# OXFORDSHIRE COUNTY COUNCIL'S RESPONSE TO CONSULTATION ON THE FOLLOWING DEVELOPMENT PROPOSAL

**Application no:** 23/00390/F

**Proposal:** The erection of an industrial Rubb storage building, extension of the existing industrial building to create a new visitor reception, external alterations to elevations, reconfiguration of the existing open service yard and car park, provision of photovoltaic (PV) panels on roof and associated landscaping and works

## **Lead Local Flood Authority**

APPENDIX H

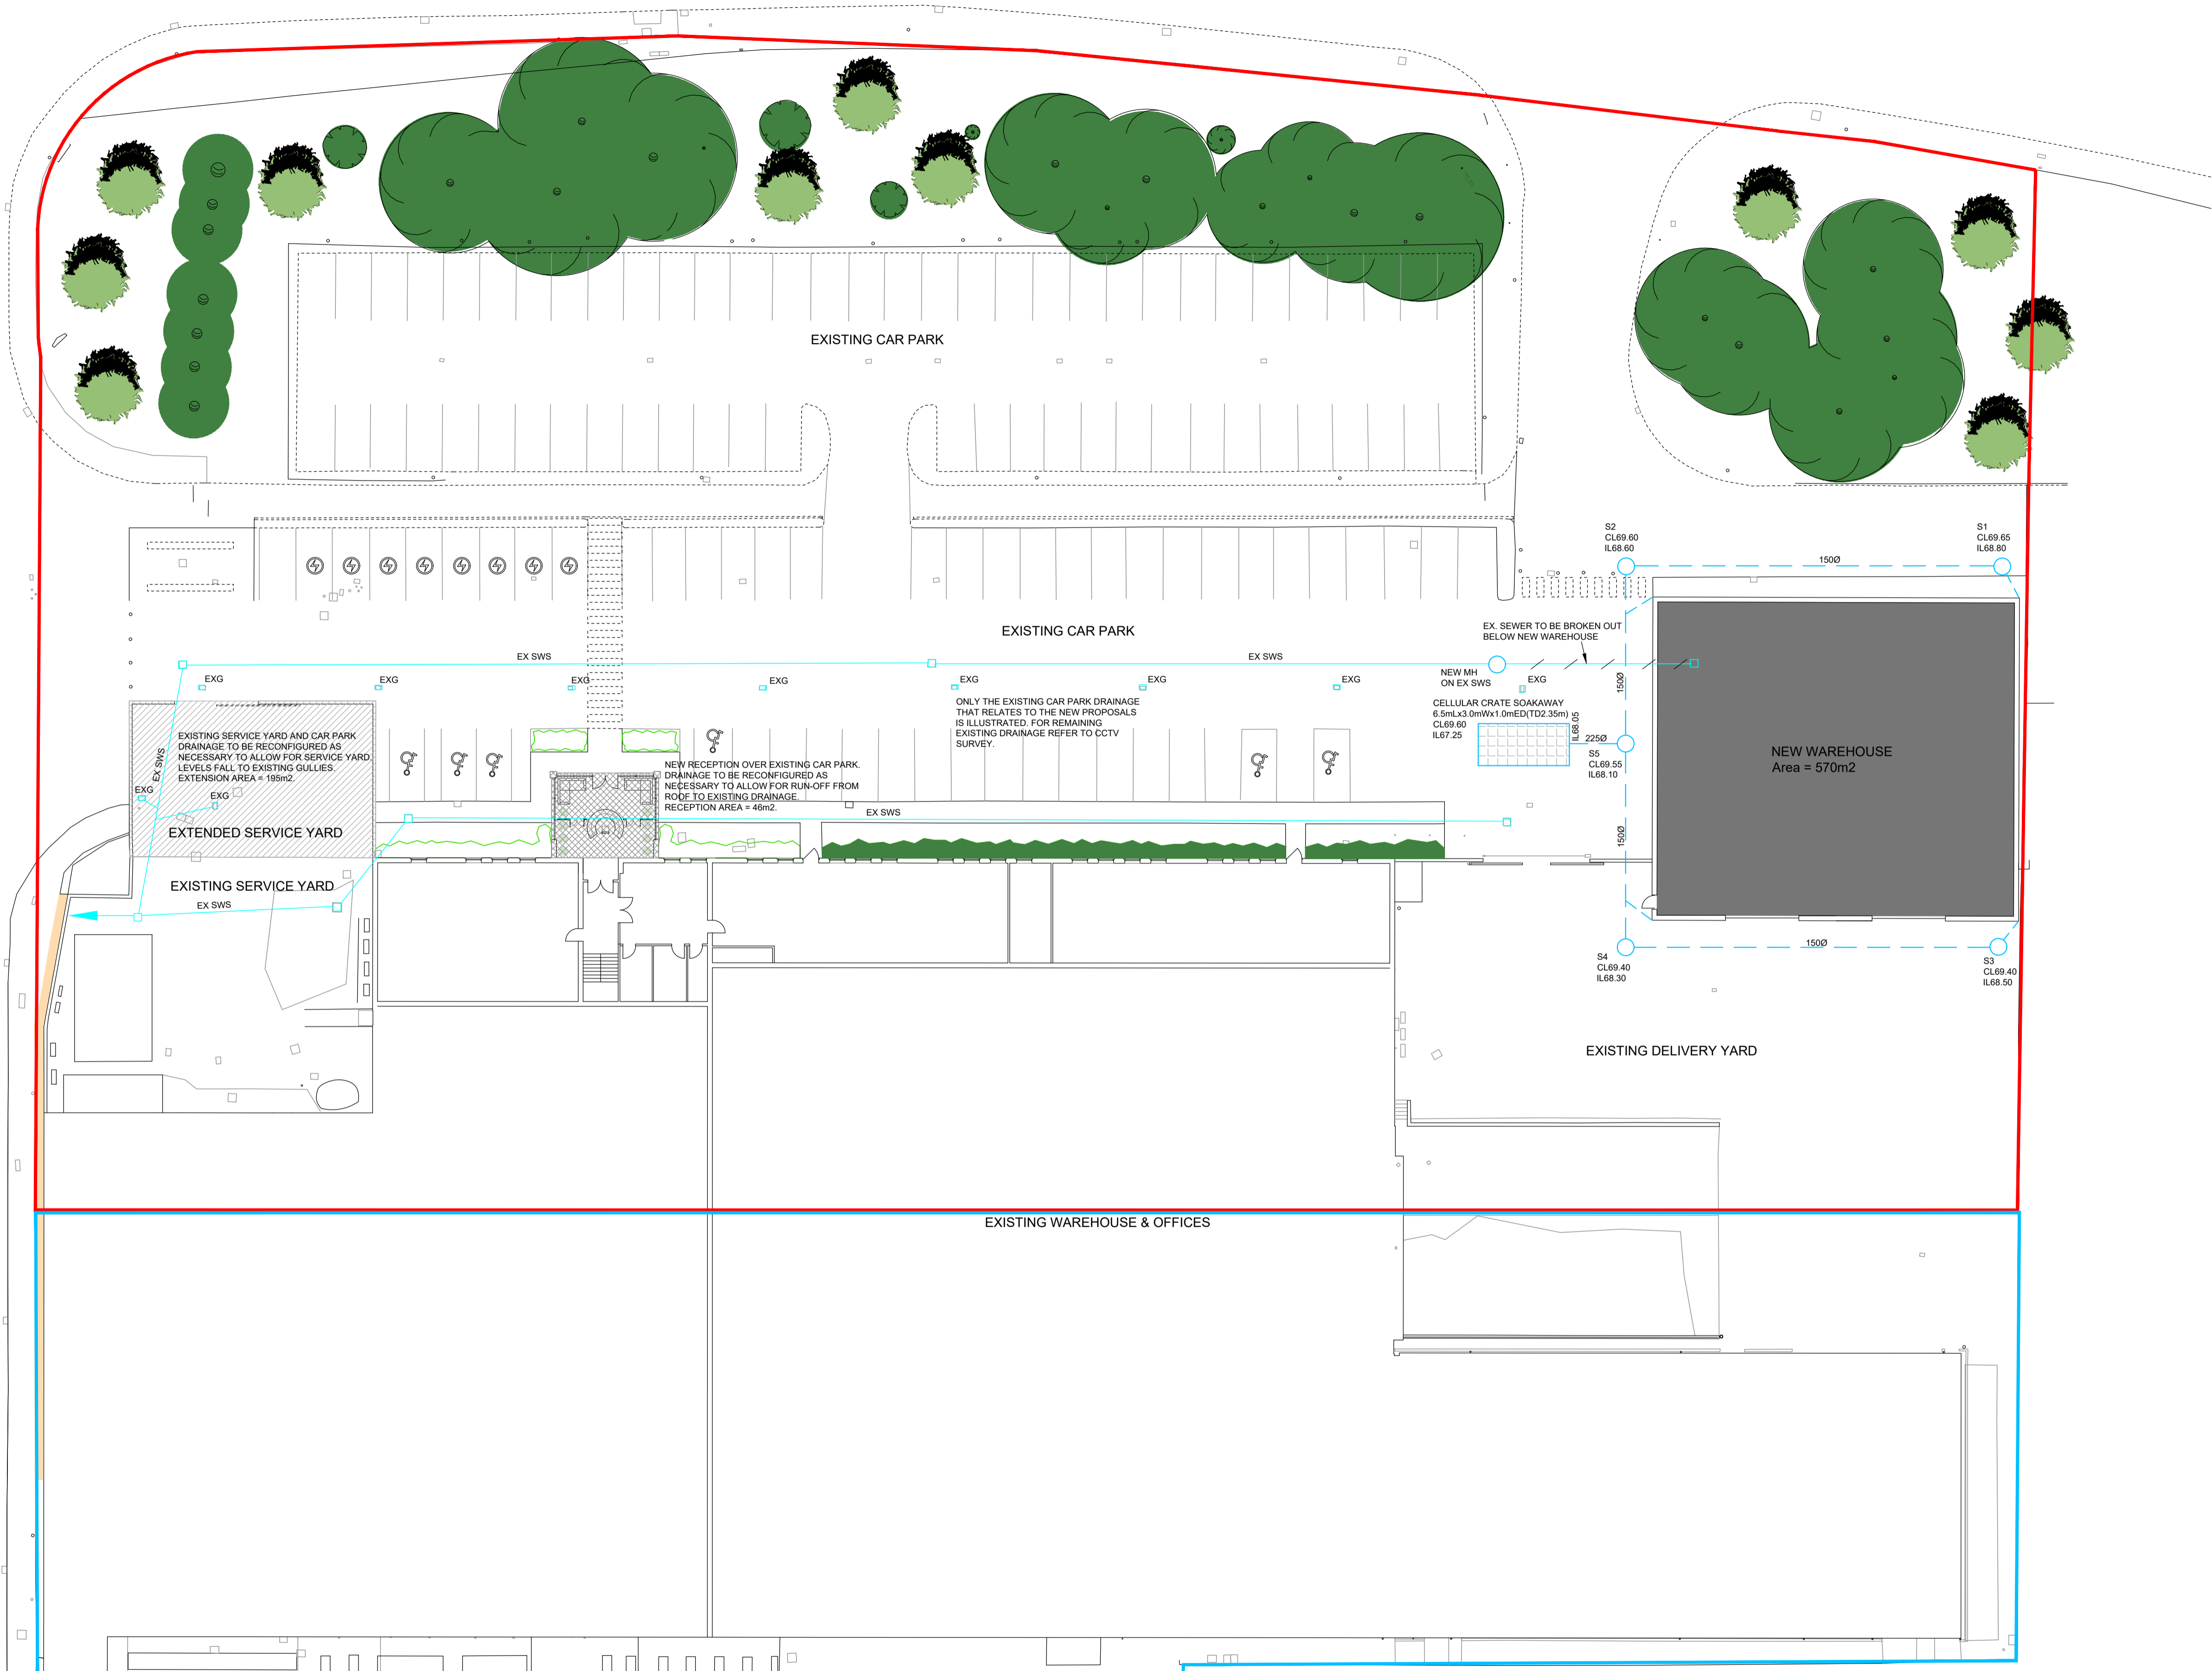
The drainage strategy is unclear in some areas. The extended service yard and parking area reception area, how this area will be draining and being picked up by the existing drainage is unclear. Manhole size to be included for the new manhole and pipe gradients to be shown for the proposed drainage.

The existing sewer that will be broken out next to the new warehouse, the new connection is not demonstrated and how the drainage will outfall from the new manhole. All proposals needs to be clear and demonstrated on the drainage drawing.

Provide remedial works on the drainage strategy drawing for the existing drainage infrastructure.
